Ref: 6/2018/2498/LB  
Date: 04/12/2018

## HISTORIC BUILDINGS AND CONSERVATION ADVICE

**RE: 1-5 Park Street, Hatfield, AL9 5AT**

The application is for the change of use of the existing grade II listed building from office (B1) to 4 no. residential flats (C3) with associated internal and external alterations.

Proposed basement plan

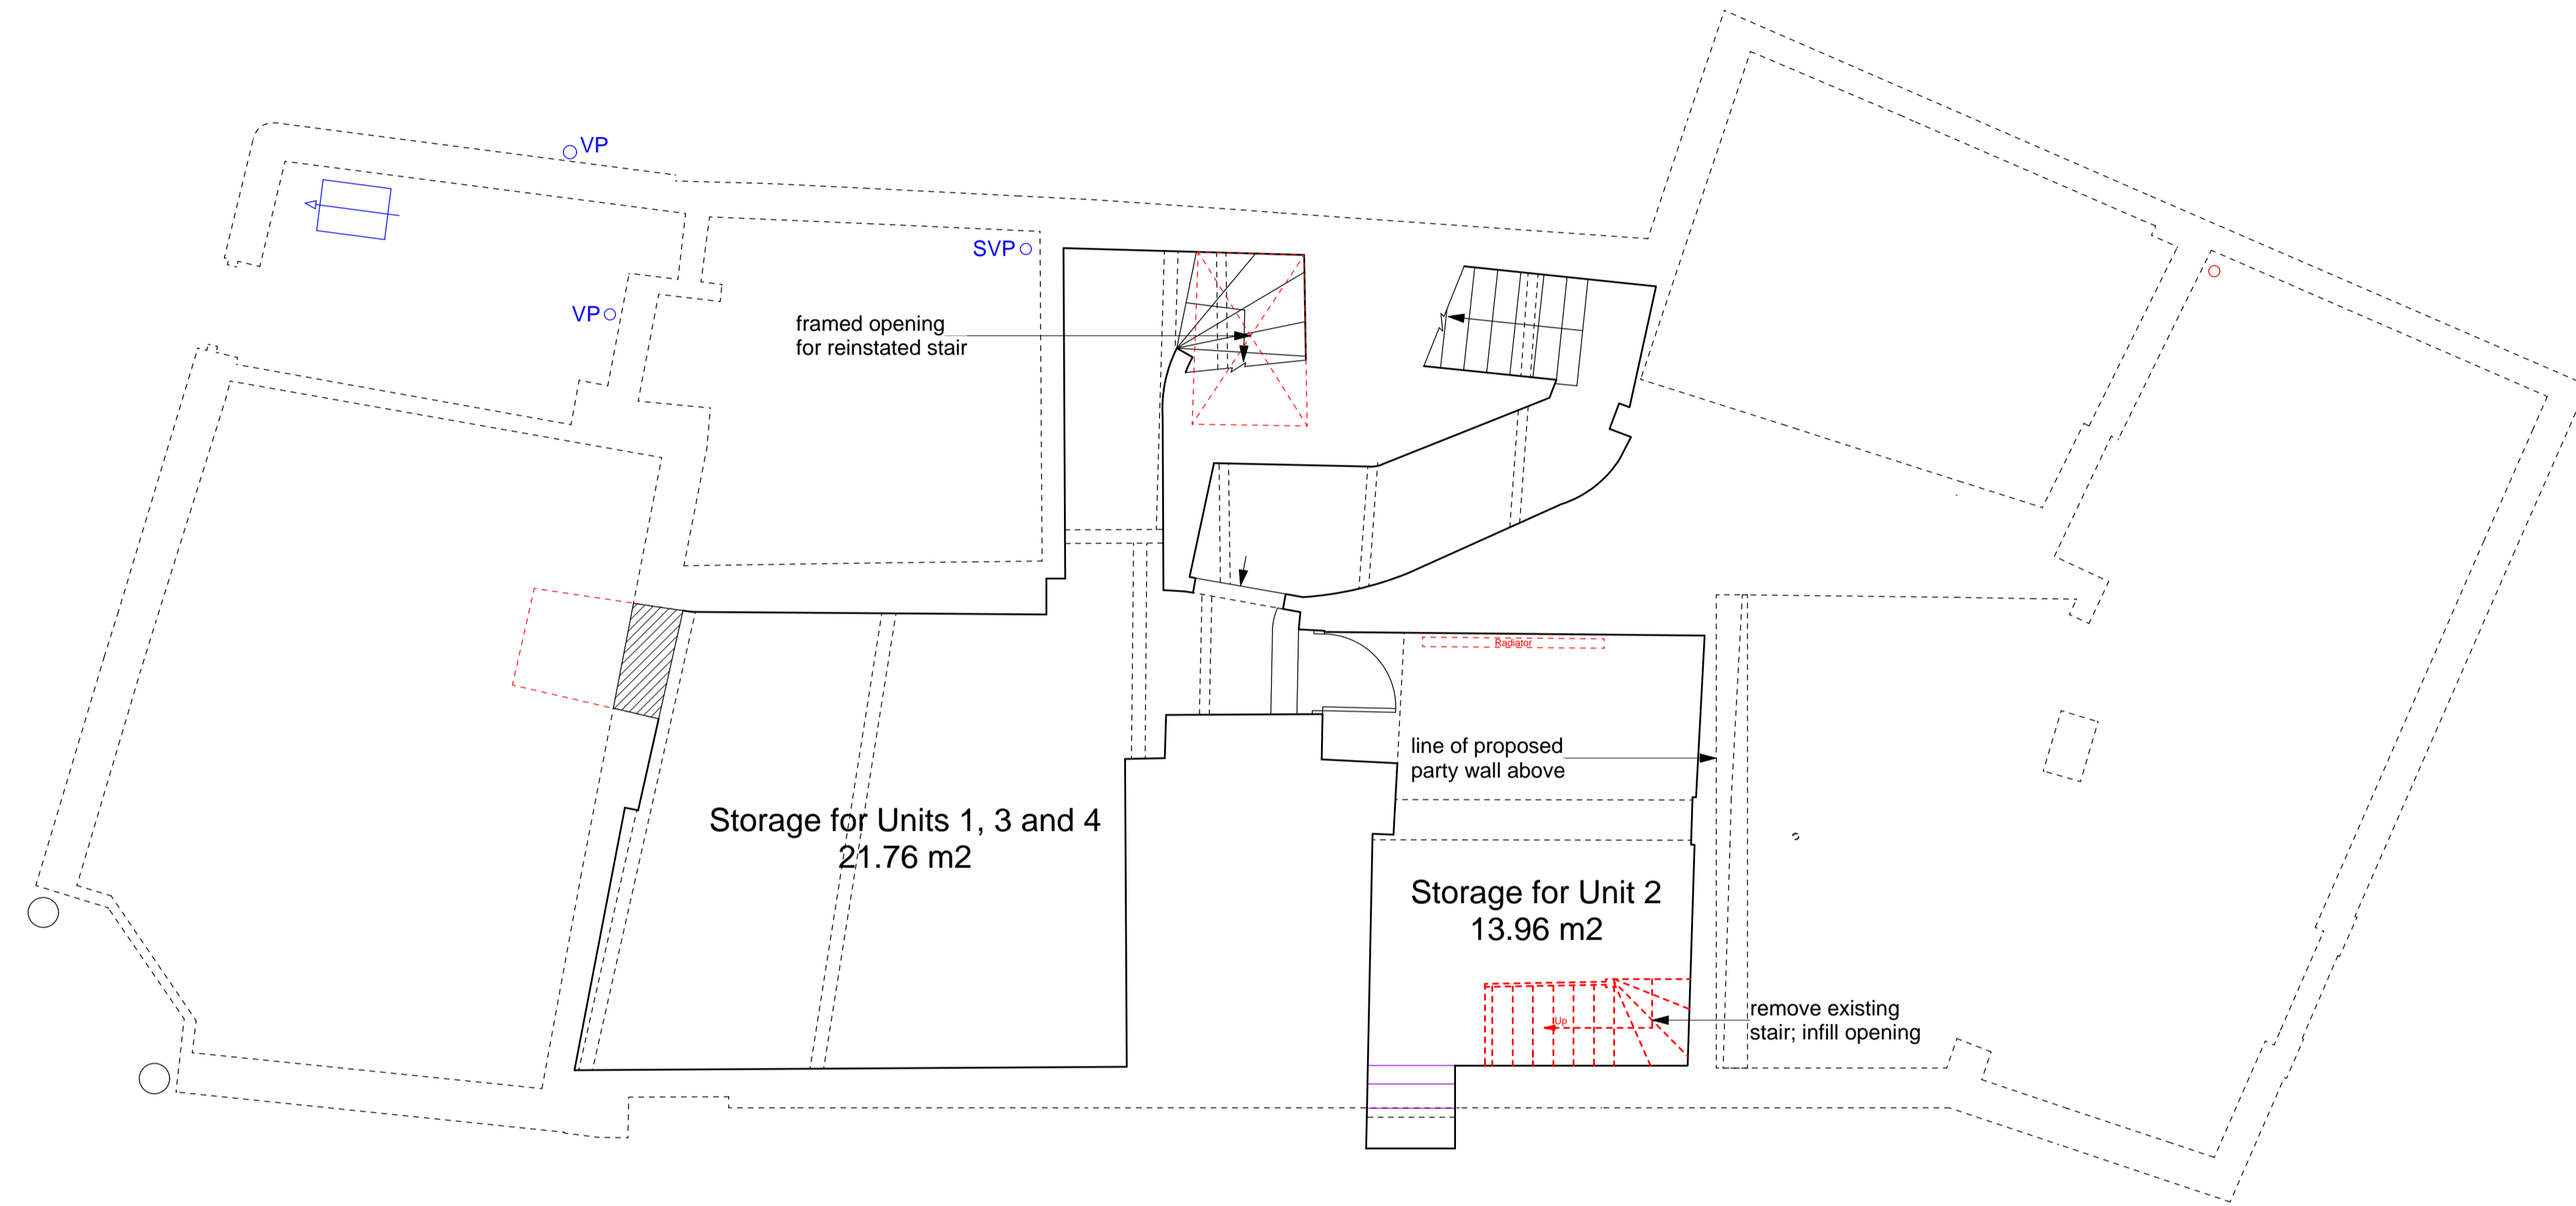
Few alterations are proposed within the basement, other than remedial works to address structural concerns, especially with the 17<sup>th</sup> century staircase, caused by poor interventions made in the 1970s. On the ground floor it is proposed to create two units, both served by existing external doors on either corner of the building. A further door will be fixed shut and left visible externally, and an existing 20<sup>th</sup> century sash window will be removed and the opening enlarged to form a doorway. Concerns were raised about the loss of this window and the potential resulting loss of the historic layout of the fenestration, however, the Planning and Heritage Statement submitted with the application has demonstrated with photographic evidence that this window dates from the mid-late 20<sup>th</sup> century as there was formerly a shopfront in this position. The proposed door will provide access to a communal hallway, enlarged slightly following pre-application comments and now better

- A written method statement of any structural interventions in relation to the staircase;
- Additional details of new windows, doors, shopfront at a large scale (1:1 to 1:20 as appropriate) in section and elevation;

Proposed ground floor plan

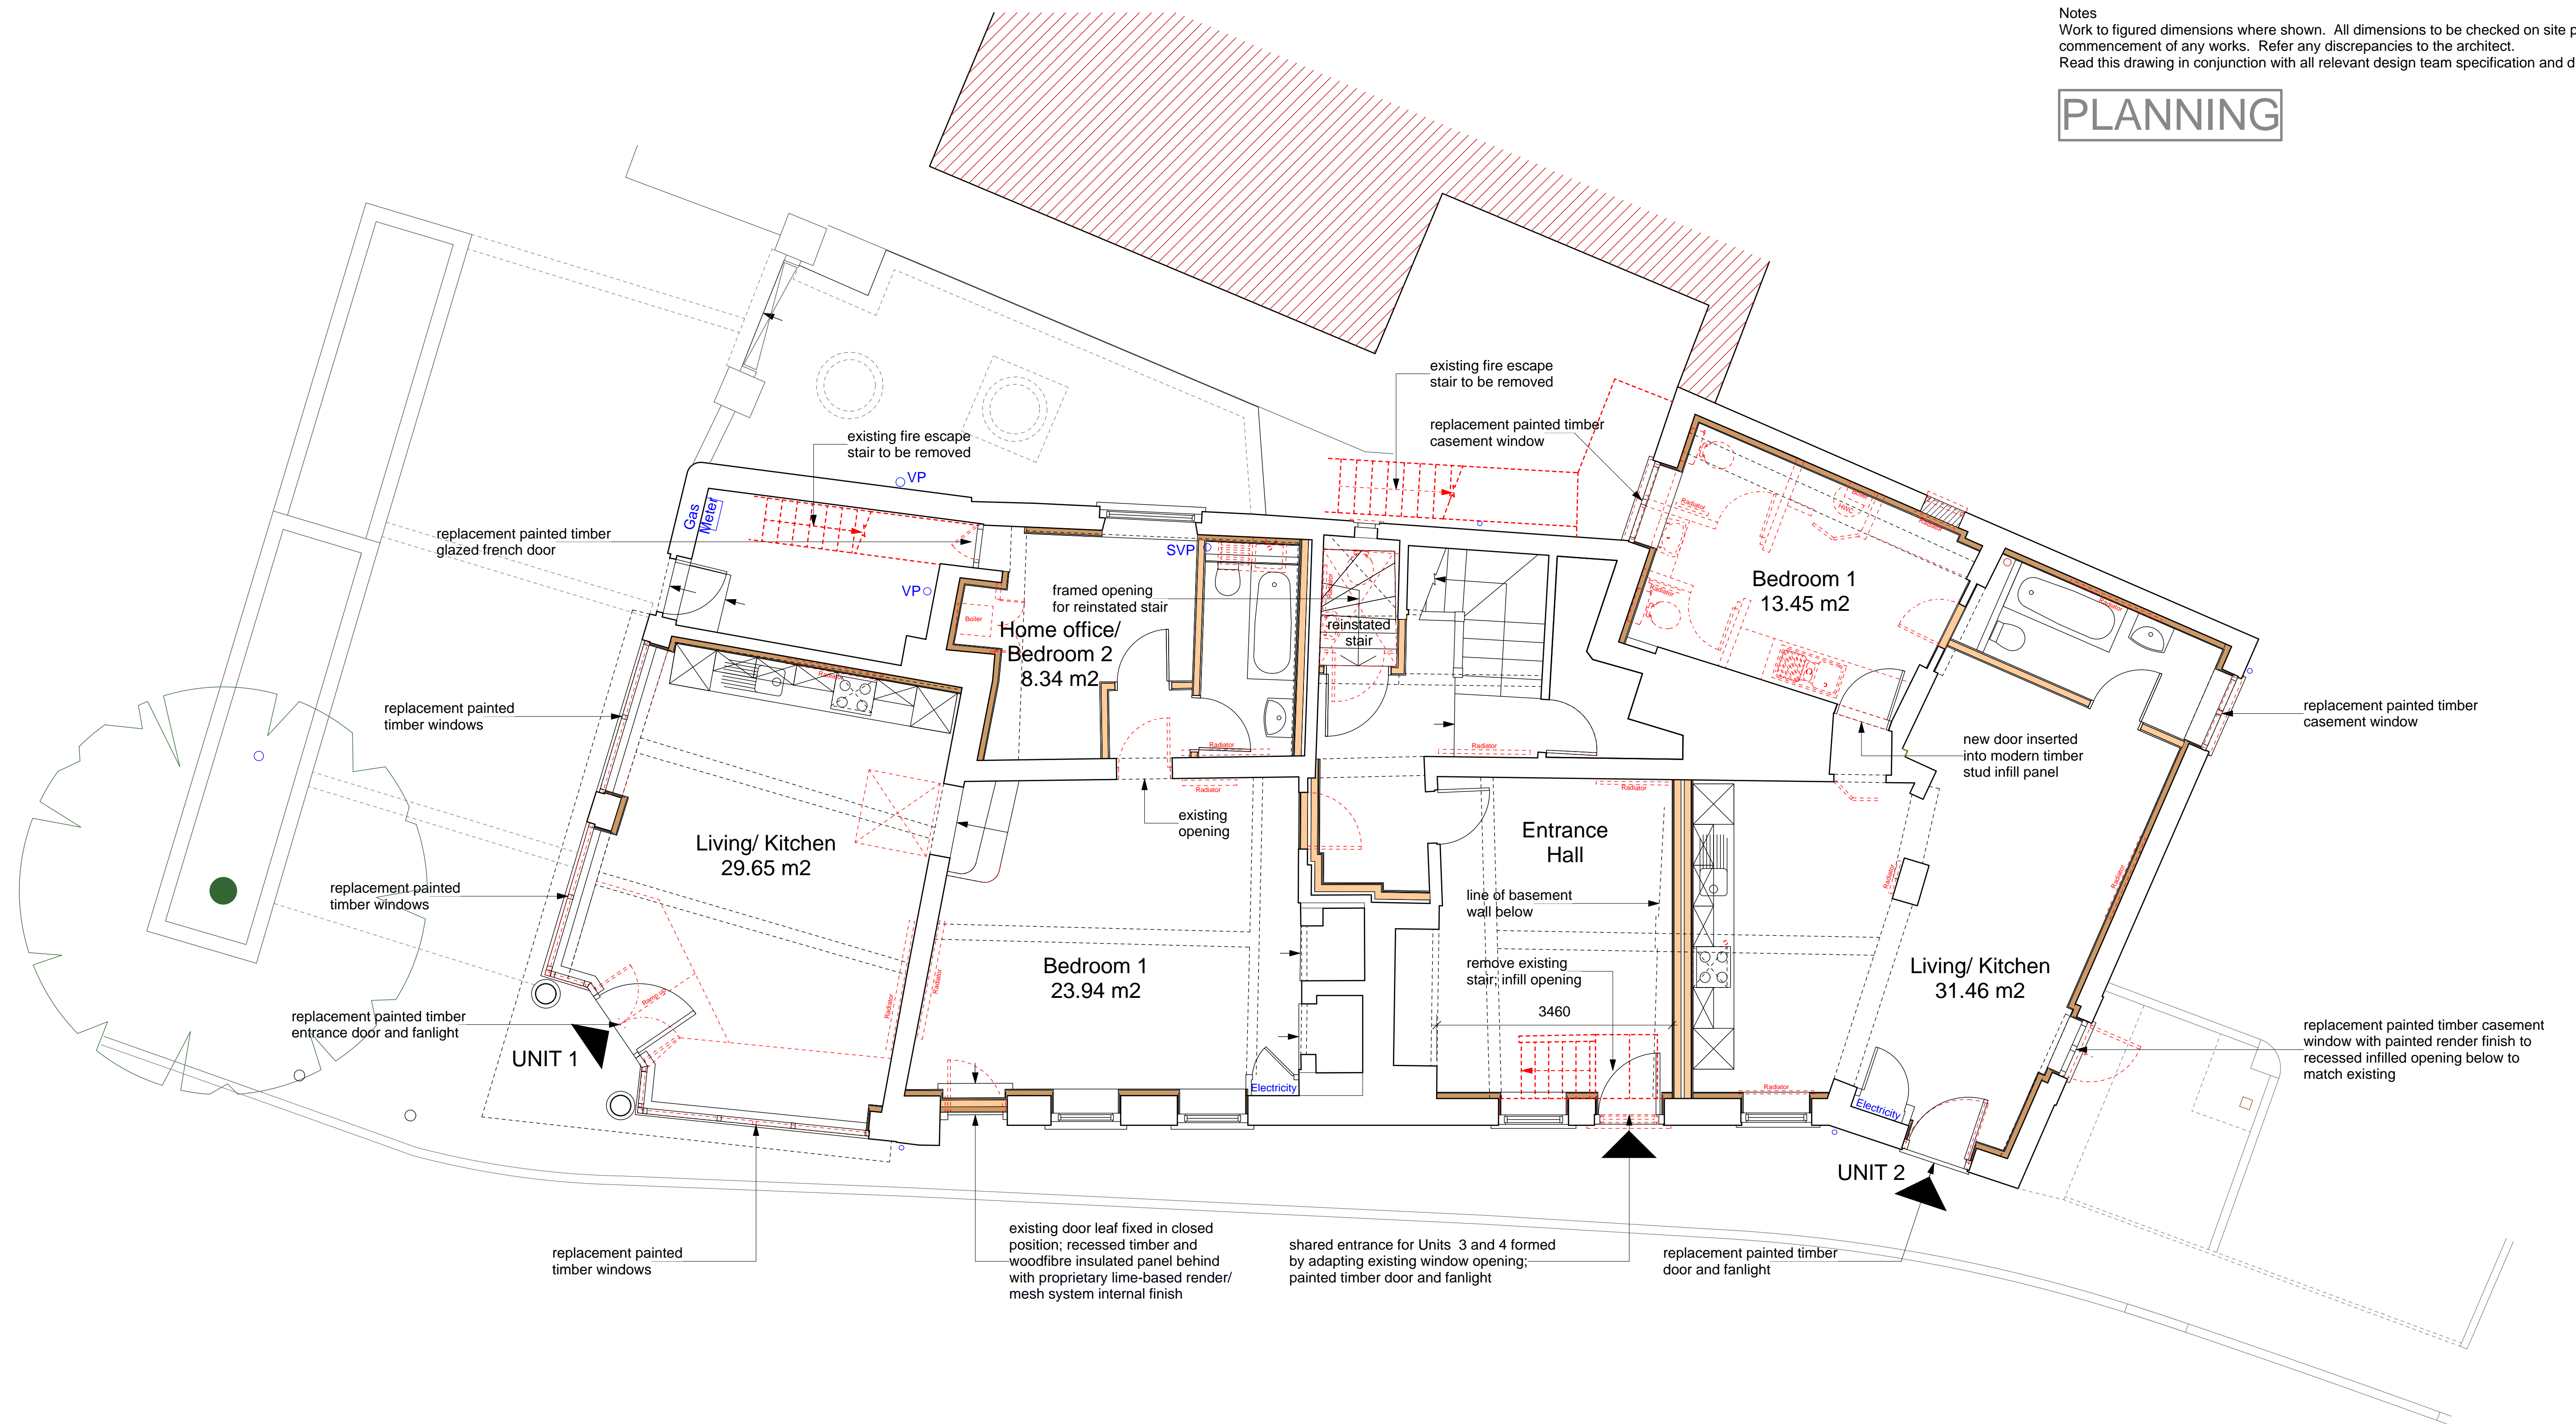
proportioned, with access through to the 17<sup>th</sup> century staircase. It is considered to be beneficial that this staircase, as a key historic architectural feature of the building, remains in communal use. Other alterations to the ground floor are also beneficial in removing late 20<sup>th</sup> century additions, including the proposed replacement of the 20<sup>th</sup> century shopfront with a more sympathetic design including fanlight and stallriser details.

Proposed first floor plan

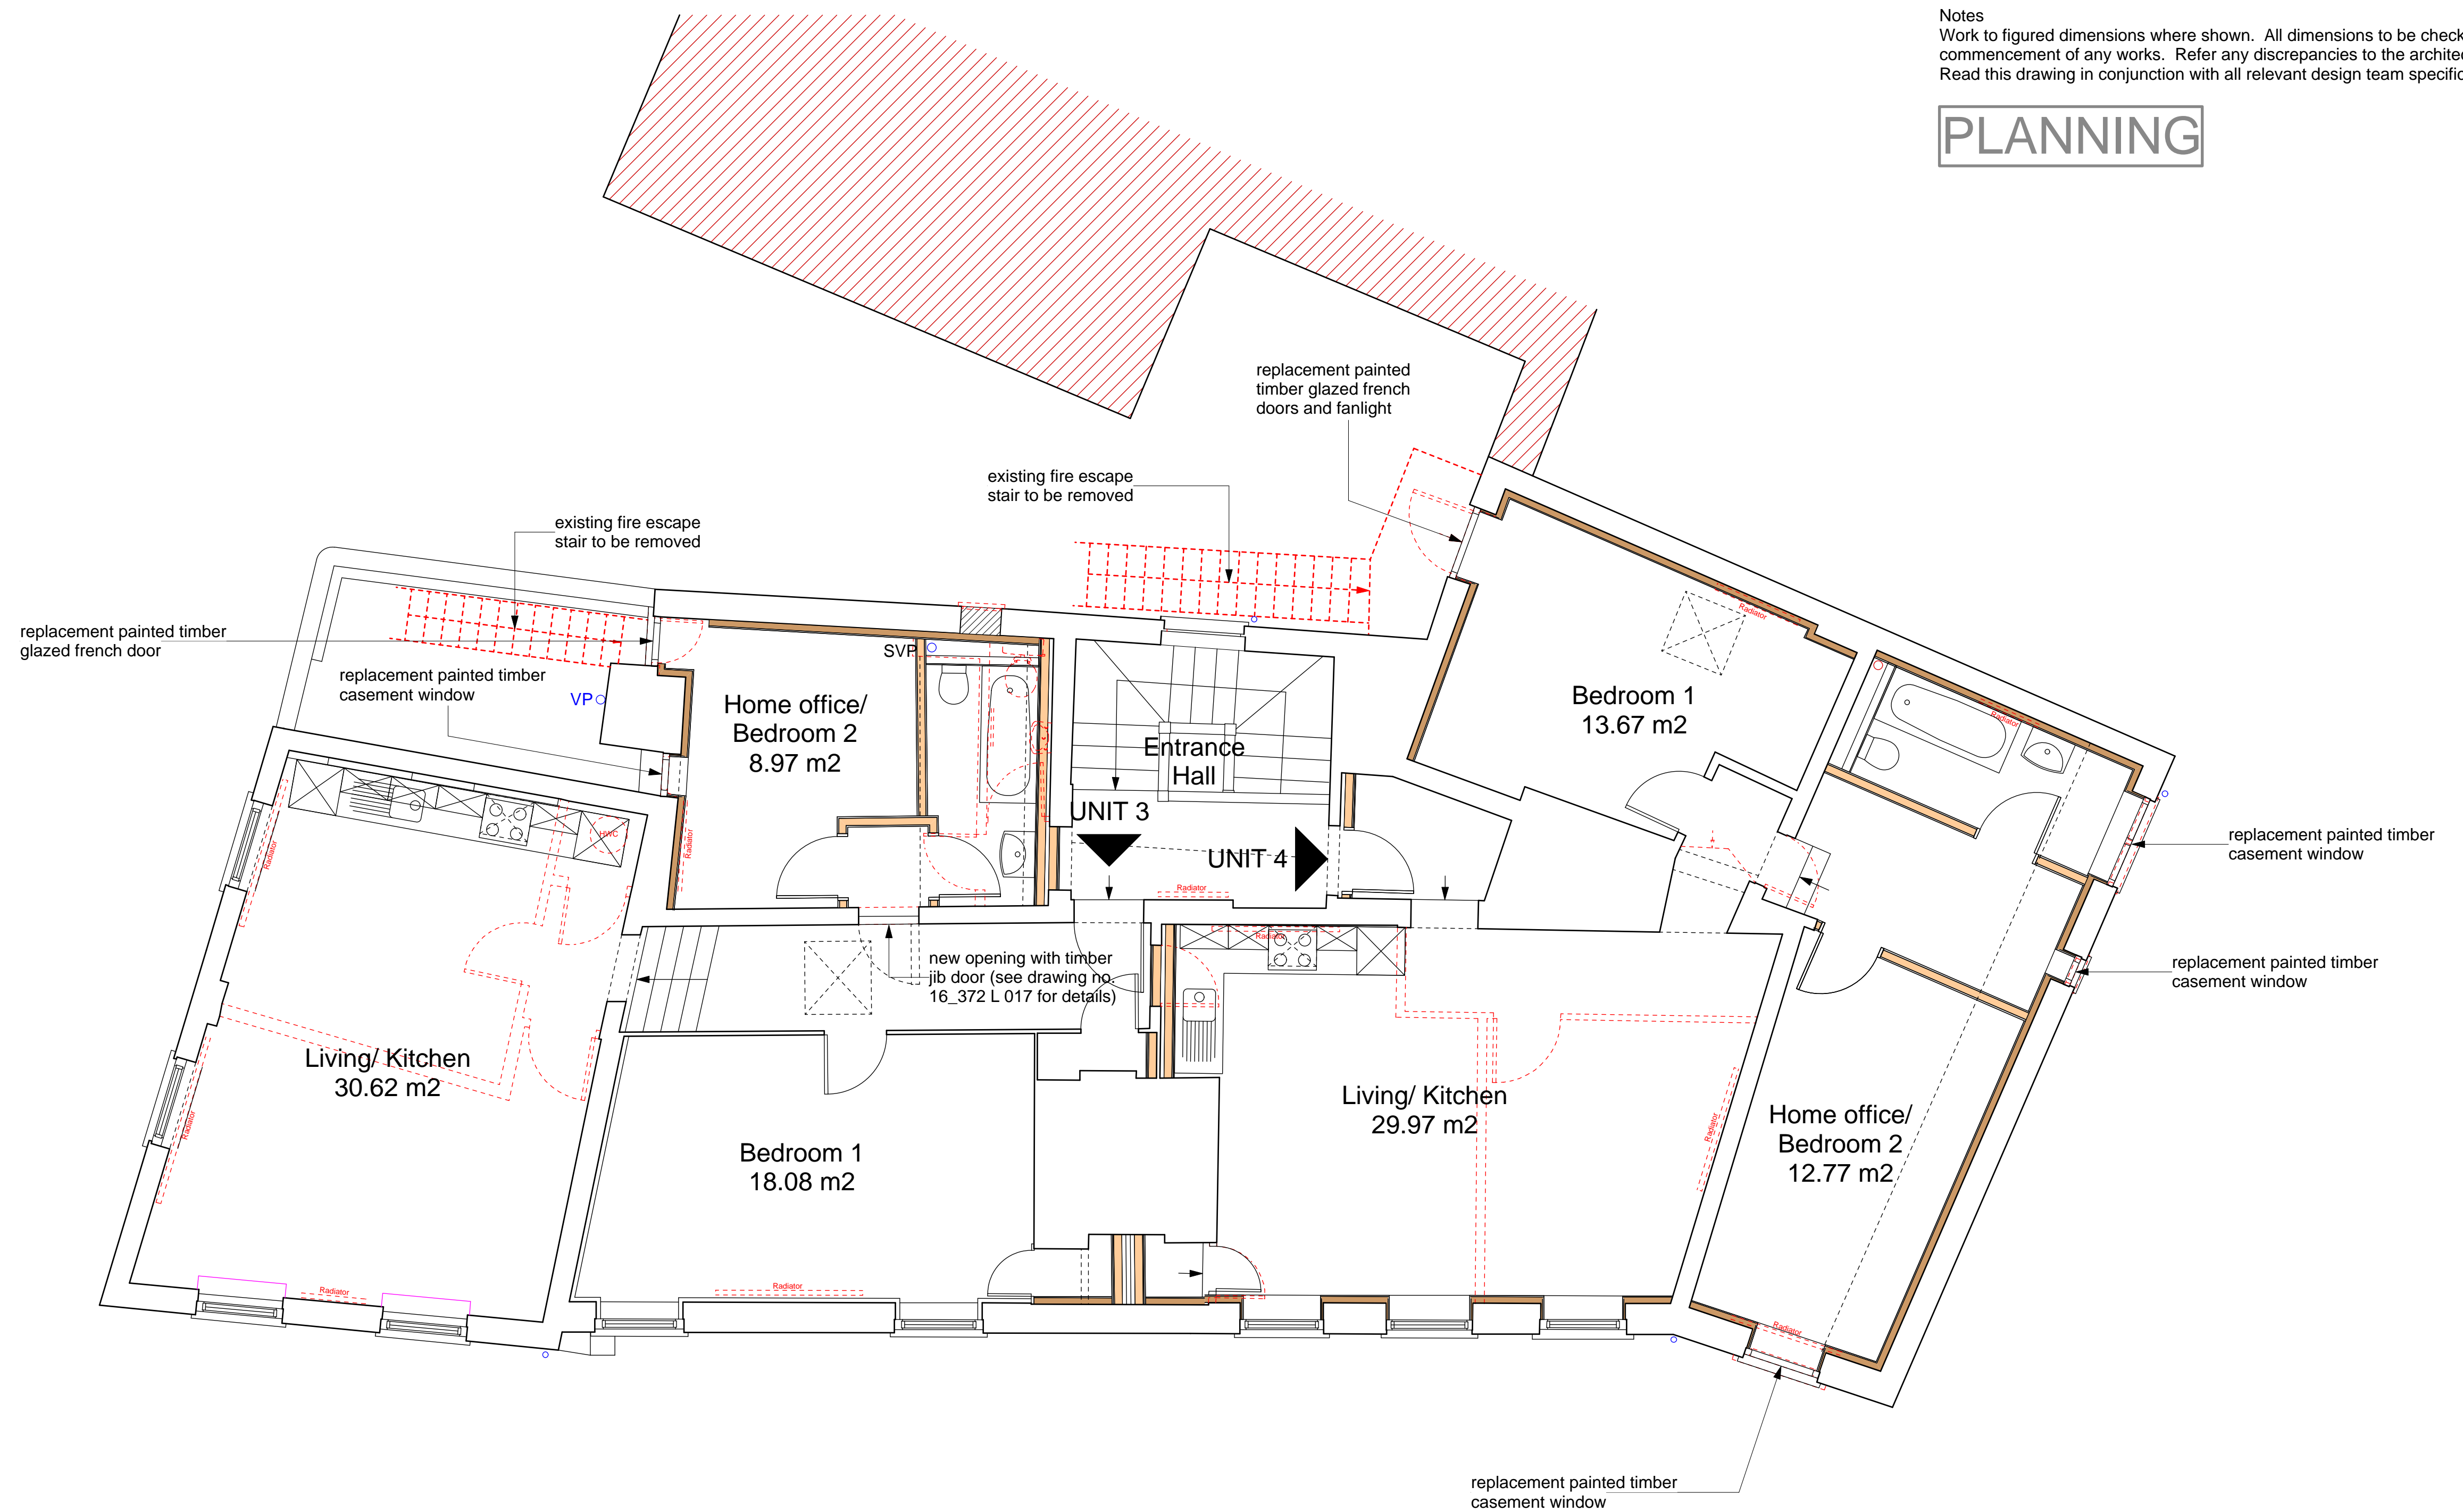
The proposed first floor alterations are also considered to be acceptable. Modern stud partitions will be removed to reinstate the original proportions, although in other less significant rooms partitions will be inserted. Concern was raised at pre-application stage about the insertion of a new doorway within Unit 3 but this had been sensitively designed as a jib door allowing the appearance of the existing panelling to be retained and concealing the door.
